Updated Acoustic Comment and Advice Proposed Preschool & Community School – 1 Rosemead Road, Hornsby, NSW

The most recent update of my acoustic assessment report in relation to the new Blue Gum Preschool & Community School proposed for 1 Rosemead Road, Hornsby, NSW is presented in the document:

Acoustic Assessment Report: Proposed Preschool & Community School – 1 Rosemead Road, Hornsby, NSW (NG Child & Associates; Version 5; May 6th, 2020.

Title
SITE AND ROOF PLAN

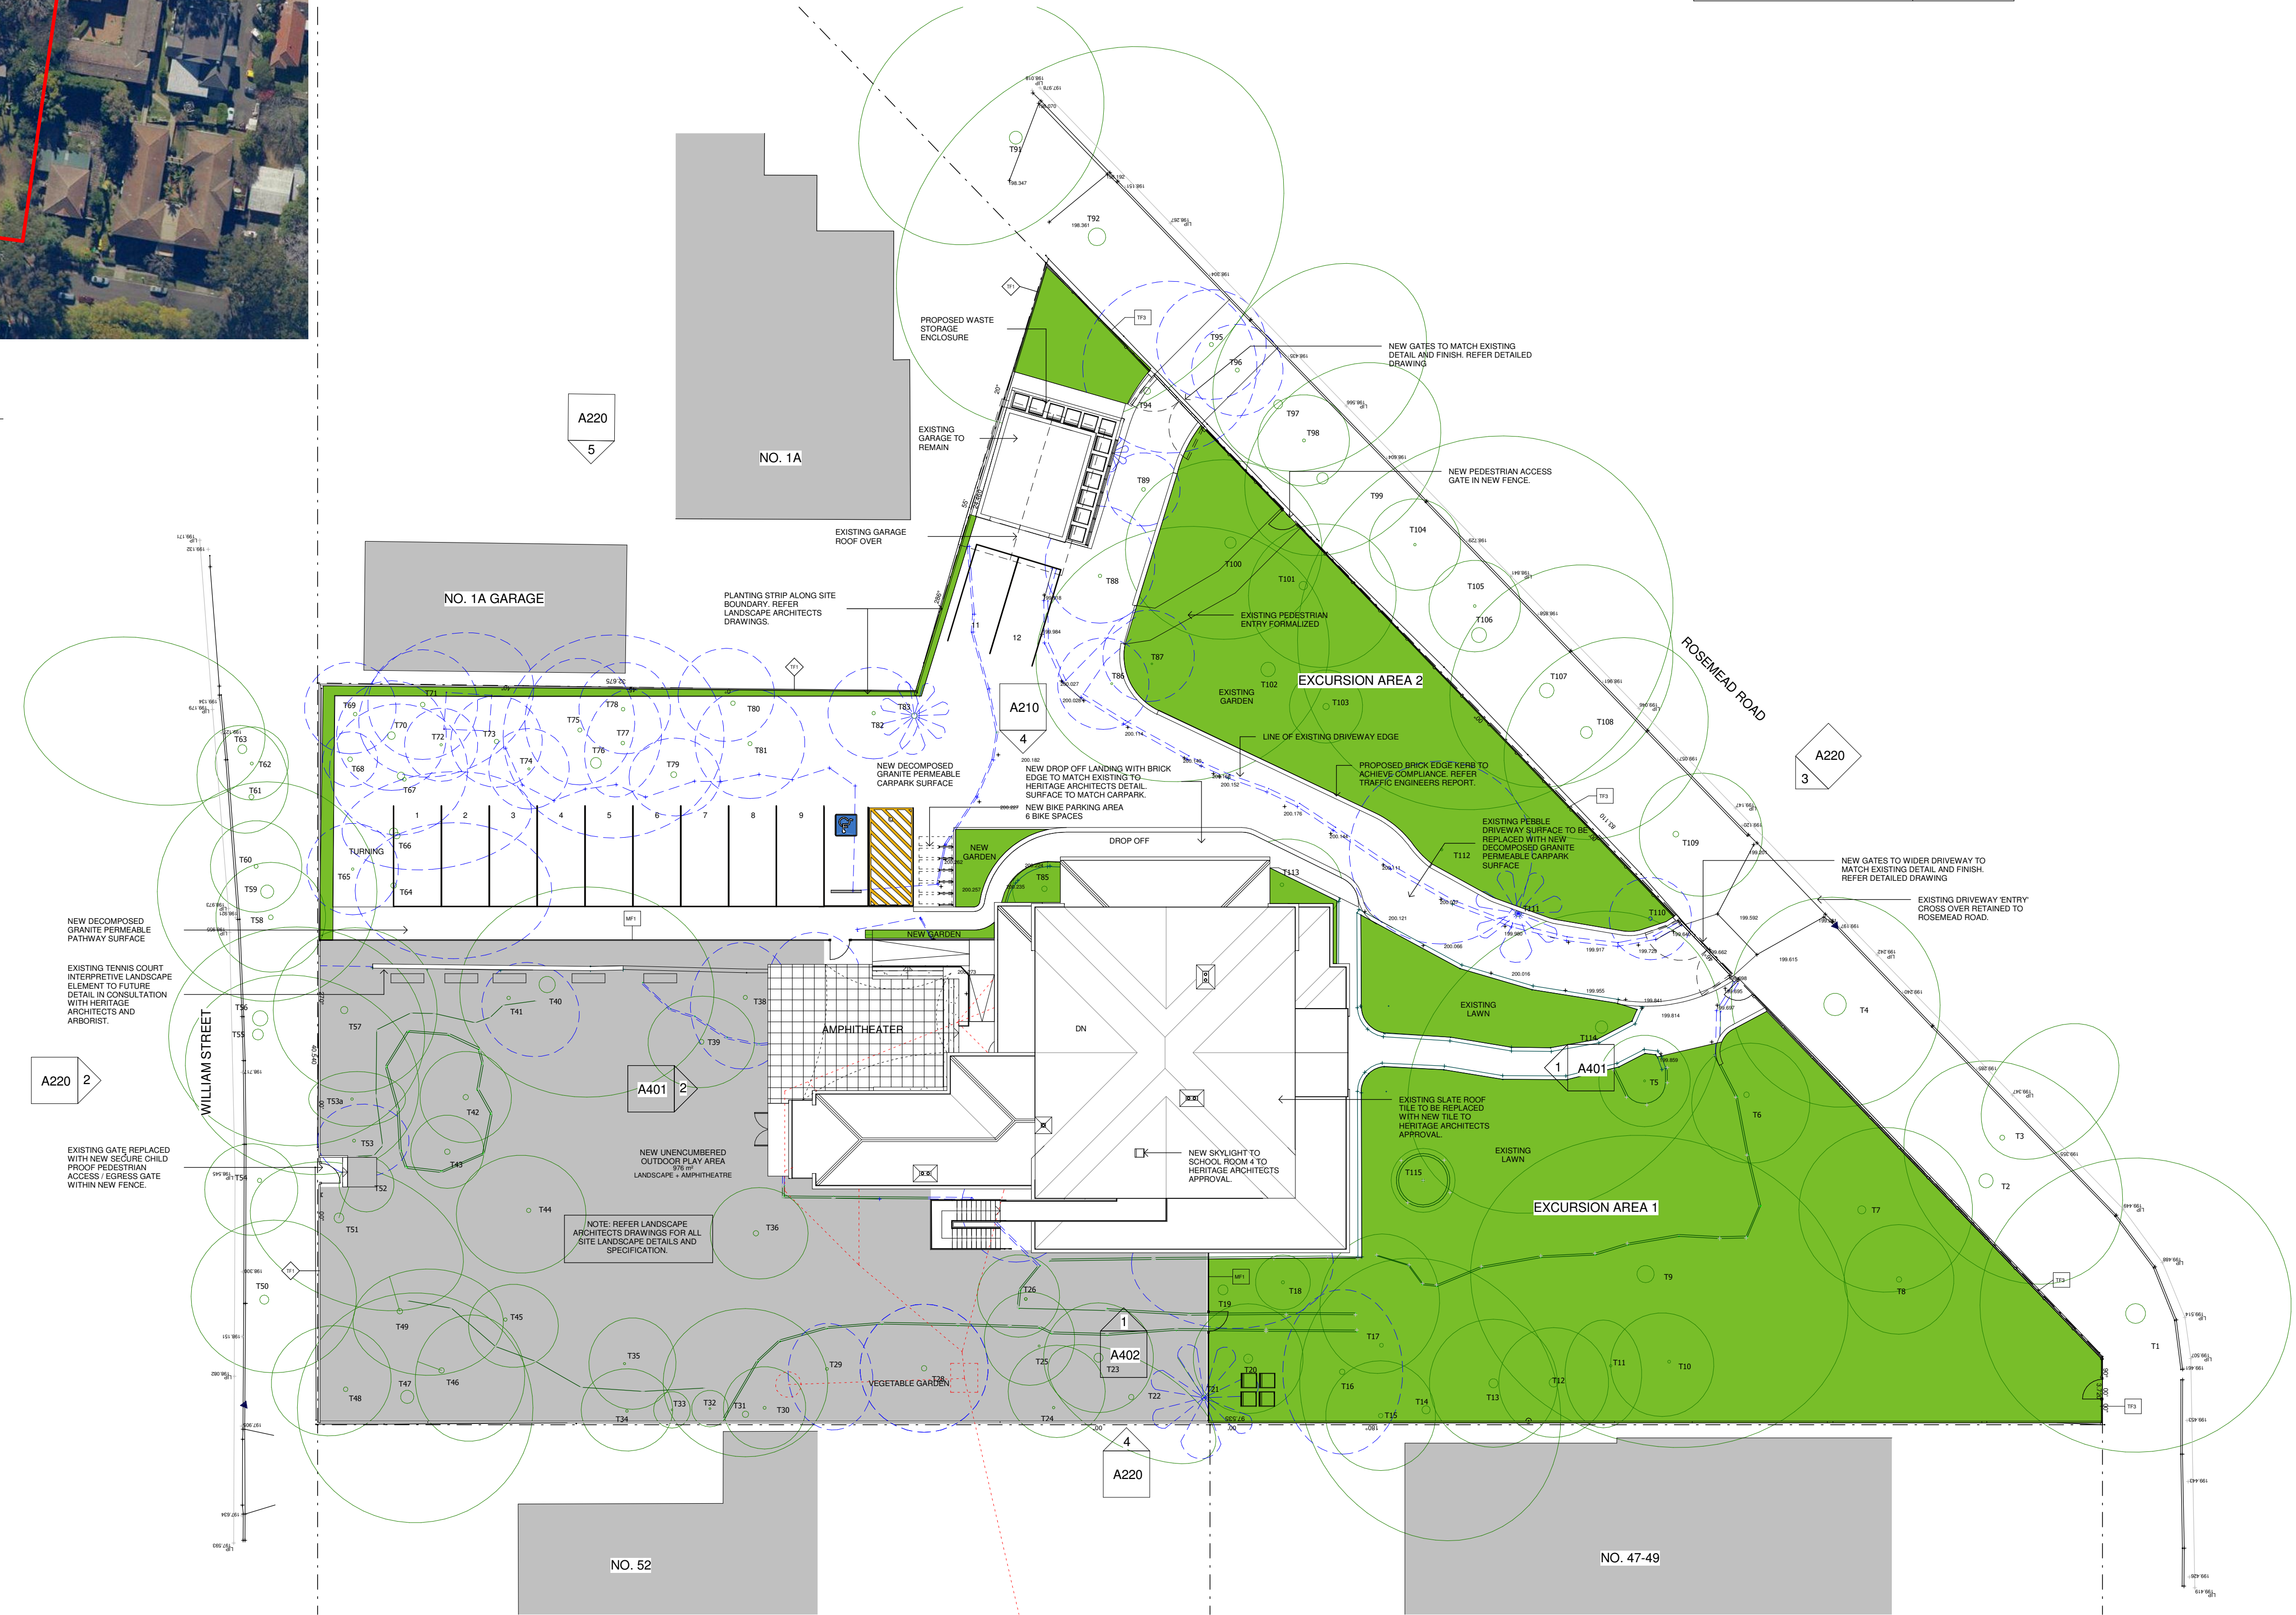
1. **Changed Car Park Layout:** Transfer of the proposed car parking spaces from the 1A Rosemead Road boundary of the car park to the opposite side of the car park, adjacent to the outdoor play area, coupled with a proposed reduction in the height of the boundary acoustic fence between the car park area and the 1A Rosemead Road property from 2100 mm to 1800 mm.
2. **Gradual Reduction in Height of Side Fence:** A gradual reduction in the height of the proposed 1800 mm side fence between the development and the 1A Rosemead Road property near the front or Rosemead Road site boundary where the side fence will intersect the 1200 mm non-acoustic front property fence.
3. **Change in Fence Style on William Street Boundary:** Replacement of the proposed 1800 mm lap and cap timber acoustic fence with a more open non-acoustic fence along the rear or William Street site boundary.

Version 5 of my acoustic report involved an increase in the recommended height of the acoustic fence proposed for the boundary between the car park area and the adjacent residential property at 1A Rosemead Road from 1800 mm to 2100 mm.

In my opinion, the transfer of car spaces to the opposite side of the car park overcomes the need for additional fence height by introducing greater distance between the actual car parking activities and the affected residential boundary.

Version 5 of my acoustic report included an 1800 mm high double lapped and capped timber acoustic fence along the south-western boundary fence section between the development site and the adjoining property at 1A Rosemead Road, which is the fence section between the car park area and the front or Rosemead Road boundary.

What is proposed is a gradual reduction in the height of this fence from 1800 mm to 1200 mm over the relatively short fence section between the storage shed and associated waste storage area shown on this boundary (refer Attachment 2) and the front or Rosemead Road fence line, so that the timber fence aligns in height with the 1200 mm non-acoustic front fence.

Version 5 of my acoustic report included an 1800 mm high double lapped and capped timber acoustic fence along the southern or William Street property boundary. What is proposed is the replacement of this timber acoustic fence with some other form of more open style fencing. This property boundary adjoins a roadway (William Street) and is separated from potentially affected residential receivers by that roadway. On this basis, an acoustic fence is not strictly required on this property boundary, and in my opinion the more open style non-acoustic fence now proposed involves no risk of undue or non-compliant acoustic impacts on any nearby residential or other property.

On this basis, it is my opinion that given the revised car park layout reflected in the diagram provided at Attachment 2, a solid form 1800 mm double lapped and capped timber acoustic fence will along the boundary between the proposed car park and the adjoining residential property at 1A Rosemead Road will provide sufficient acoustic protection to ensure that no undue or non-compliance acoustic impacts due to motor vehicle noise emissions are experienced at the 1A Rosemead Road residential boundary in this area.

This short fence section is not acoustically sensitive, and the proposed gradual reduction or "rake-down" in fence height is not considered to involve any risk in terms of acoustic amenity for the neighbouring 1A Rosemead Road property, while offering what would appear to be an overall improvement in terms of design and visual amenity.

Drawing No. A210 Revision K

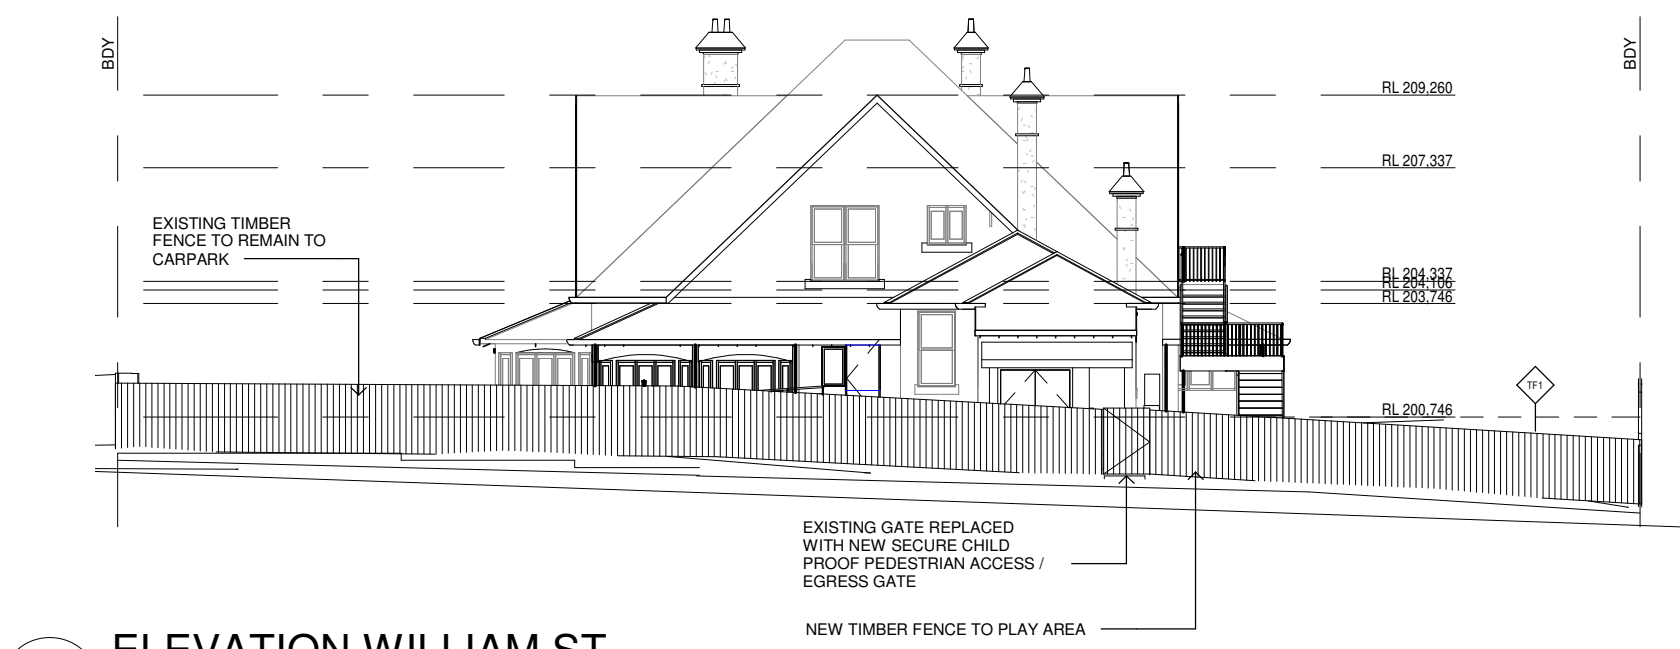
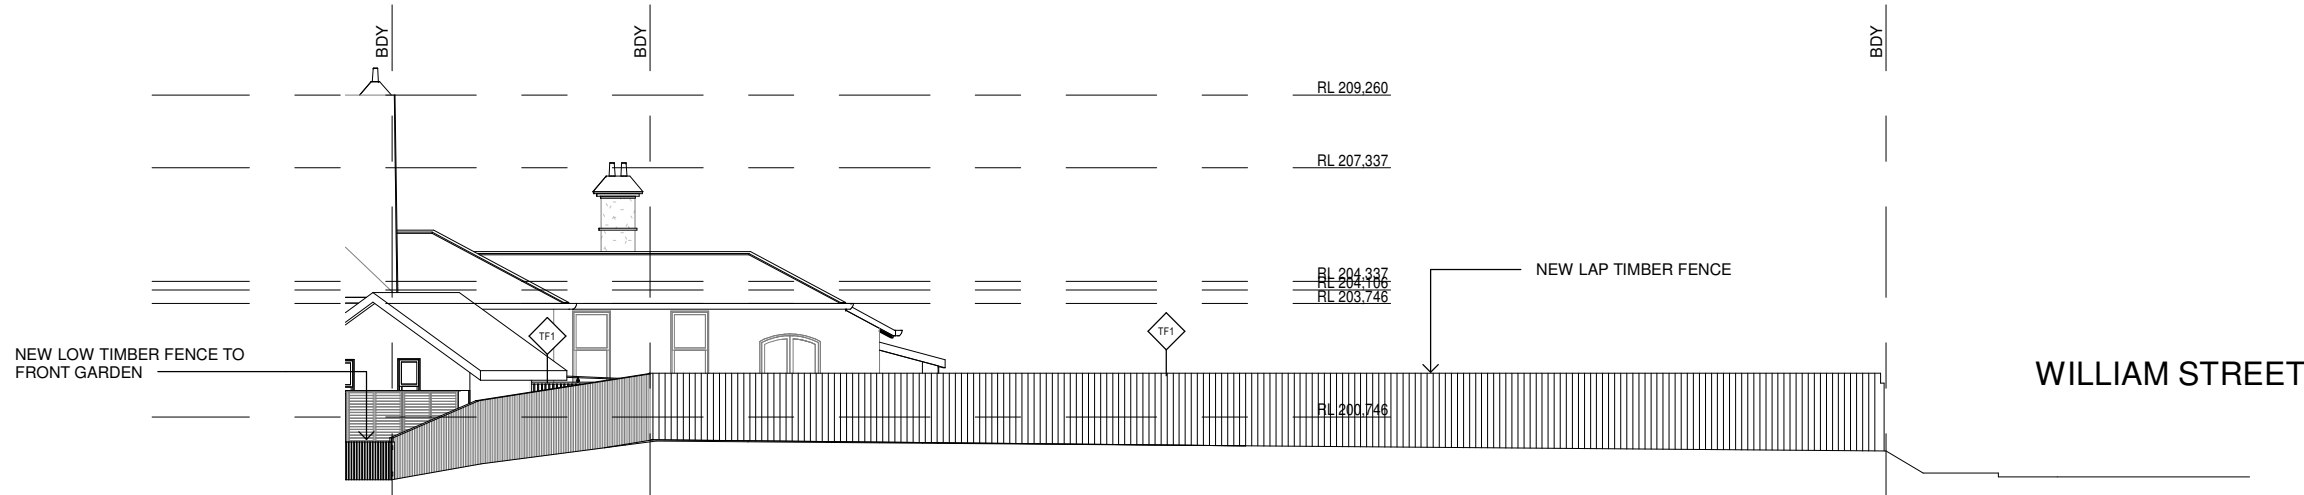
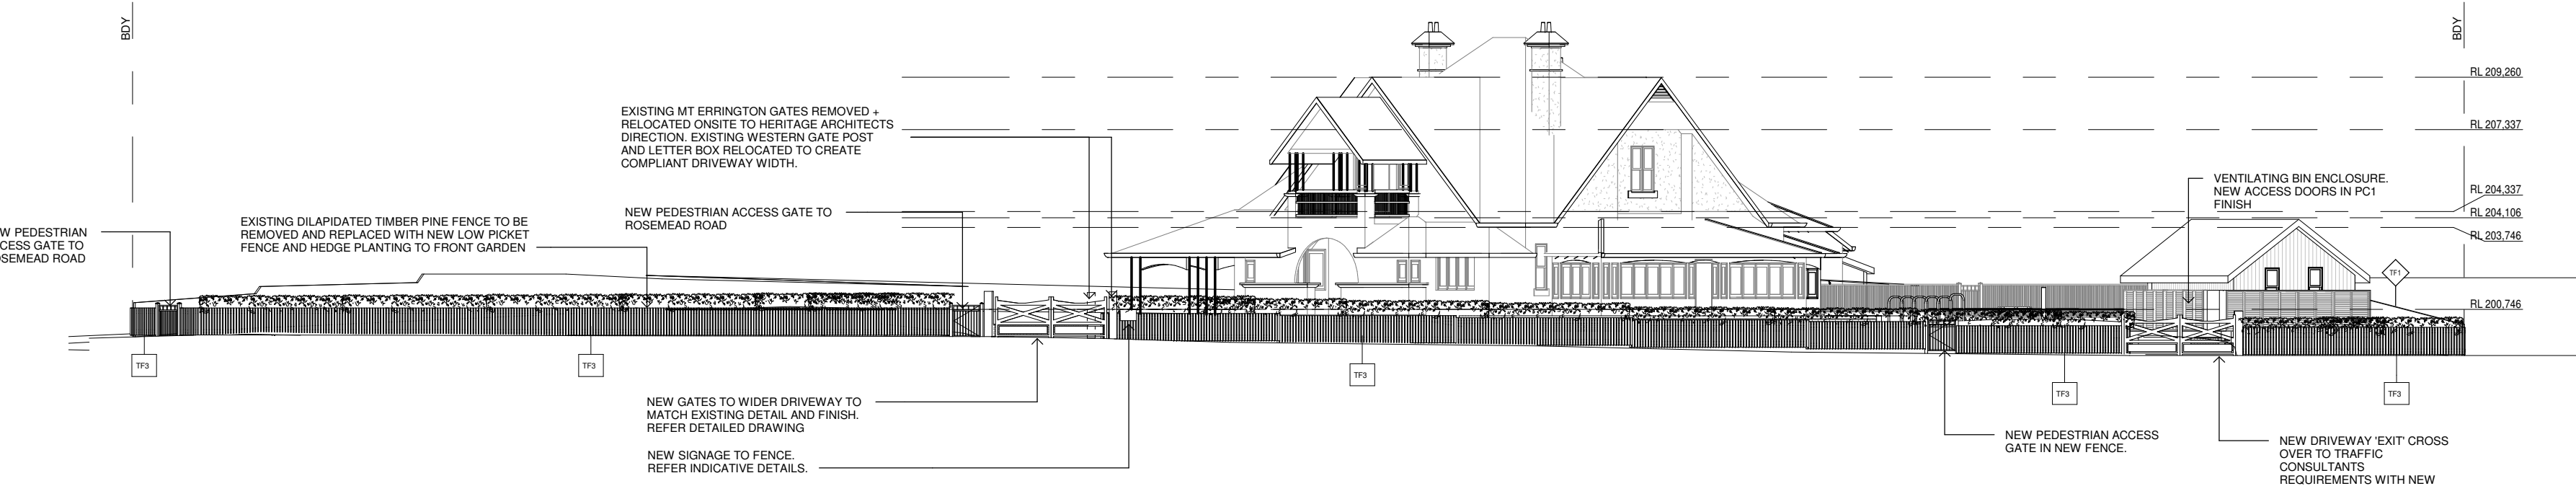
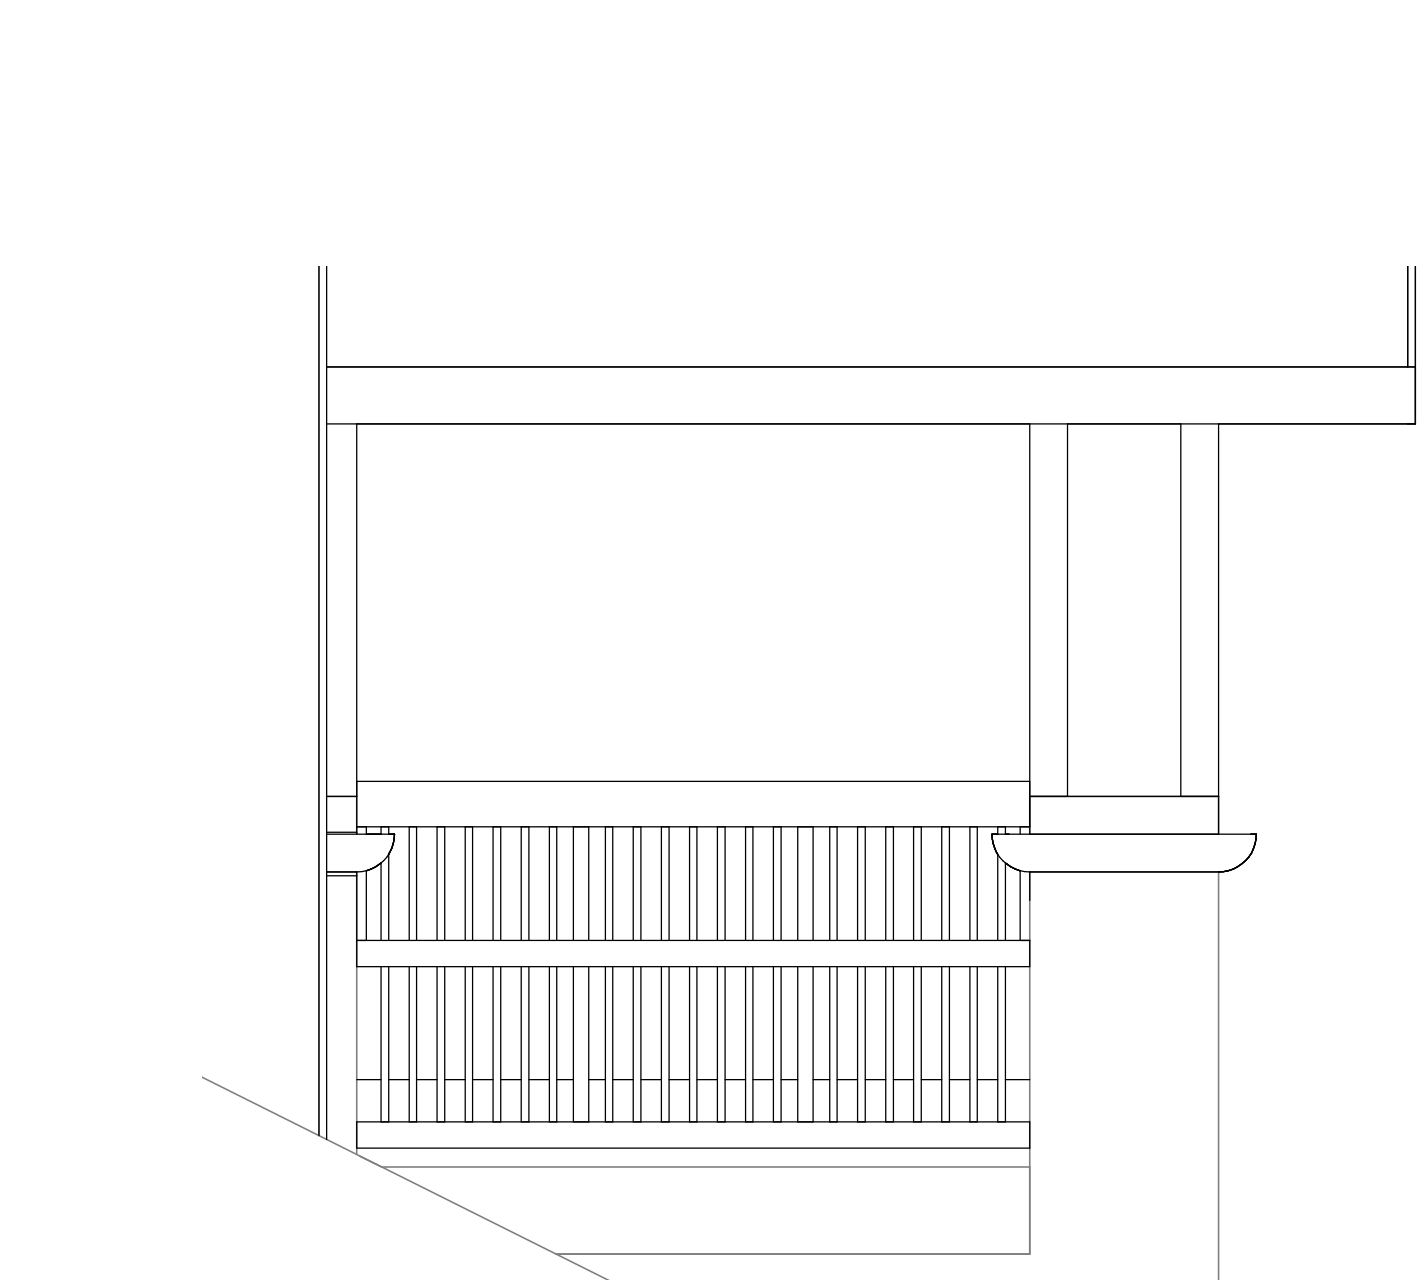
3. Change in Fence Style on William Street Boundary
